JA-19-00001

**VA-19-00001      Zoning Setback Variance      50 KITZBUHEL PL SNOQUALMIE PASS**

RE: VA-19-00001 Berlin – Deem Incomplete and Request for Additional Information

RE: VA-19-00001 Berlin – Deemed Incomplete and 2<sup>nd</sup> Request for Additional Information

Site Plan
 0' 5' 10' 20'
 1"=10'

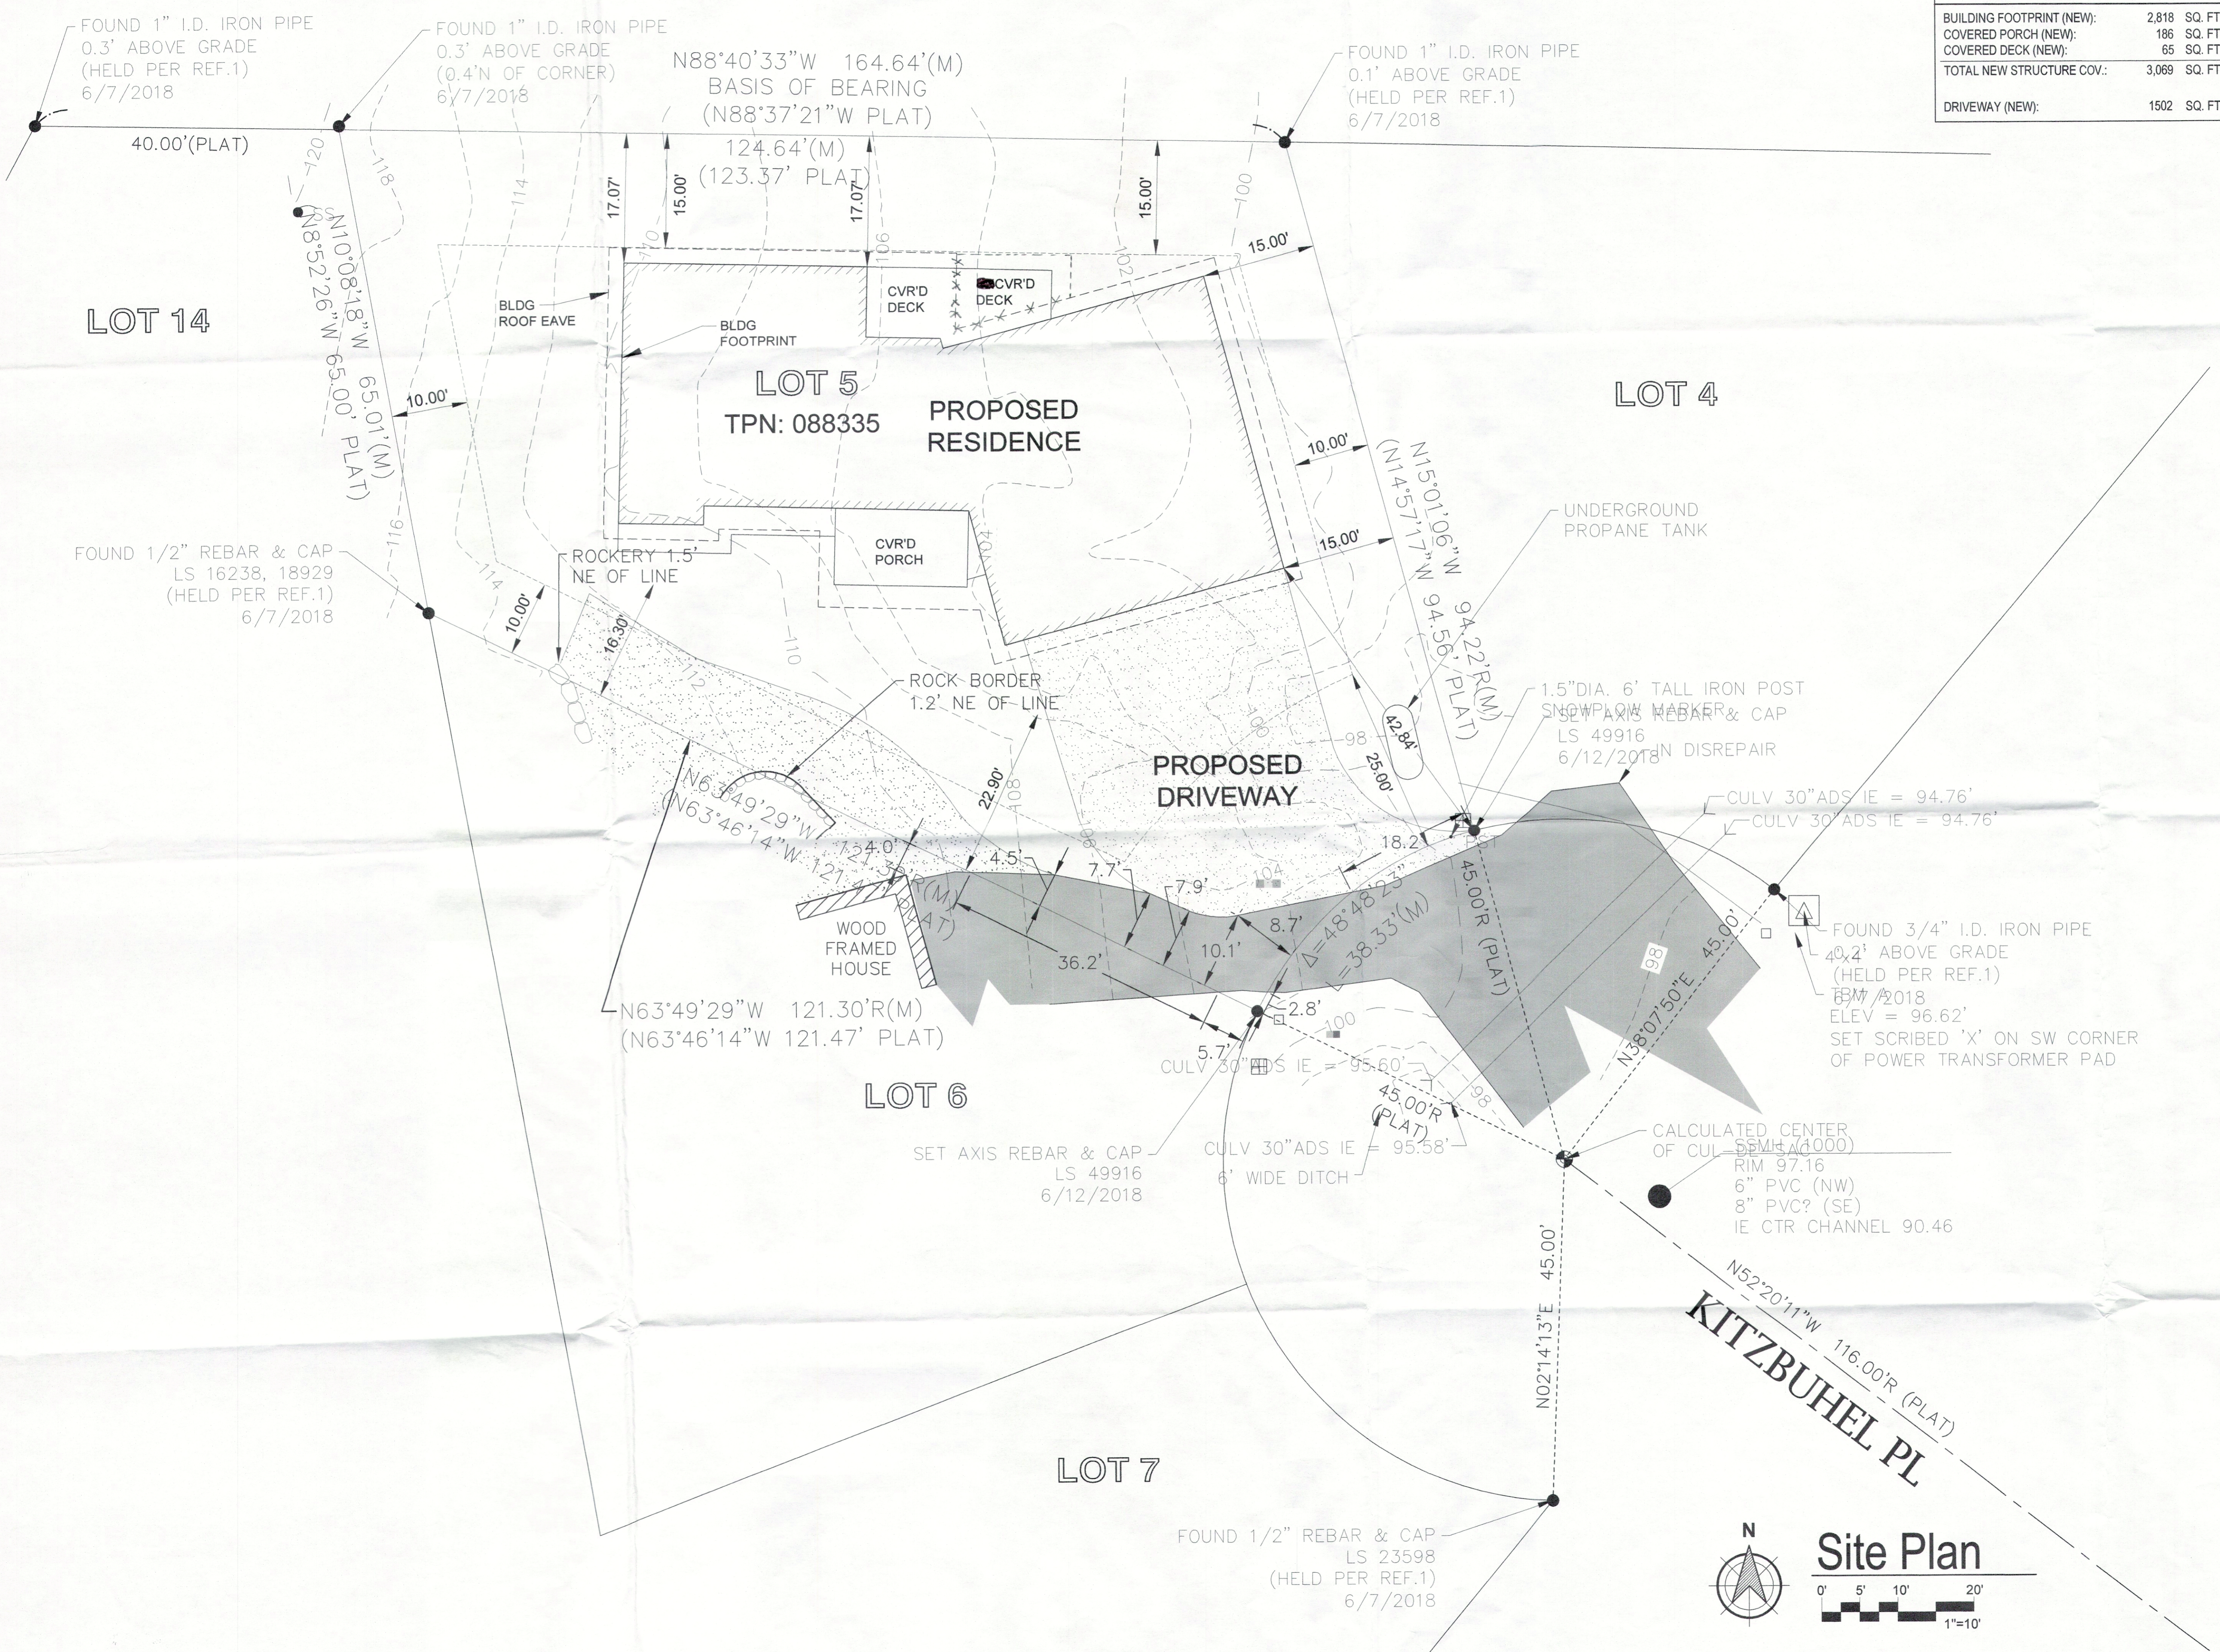
1. A revision to the site plan depicting the square footage of the proposed structure, in order to determine the proposal's consistency with the comprehensive development pattern of the area pursuant KCC 17.84.010(4) above.
2. A revision to the site plan depicting the existing setbacks under current code, and the setbacks (including reduction) for the proposed development so that CDS may review the *“proposed use and its relationship to surrounding properties”*, pursuant to KCC 15A.03(2) above.

3. Provide additional information regarding the neighbor's "encroaching" driveway and rockery, also pursuant to KCC 15A.03.030(2). Was this "encroachment" discovered by a professional surveyor? If so, please provide a copy of the survey. Is there an existing easement for the driveway and rockery in question? If so, please provide documentation.

- 1) The subject property is larger in area than most of the surrounding properties, and contains sufficient area to construct a single family residence while adhering to the required rear yard setback. The proposed 2818 square foot footprint for the proposed residence can be reduced in size to accommodate the setback in code, even if the neighbor's encroachment onto the property is considered.

- 2) The proposed residence has a larger footprint than the surrounding properties. The right to build a residence similar in area to the neighboring properties is not infringed by the property line setbacks existing in code.

1. A 2<sup>nd</sup> version of the site plan depicting the existing setbacks under current code, for the proposed development so that CDS may review the “*proposed use and its relationship to surrounding properties*”, pursuant to KCC 15A.03(2) above. The current setbacks under current code are as follows: 15 feet on the front yard, 5 feet on the side yard, and 25 feet on the rear yard, and can be found in KCC 17.16.060-080. This was previously requested in our March 18, 2019 letter (see attached).
2. A revised narrative detailing how the application meets the criteria for KCC 17.84.010(1) - (2).
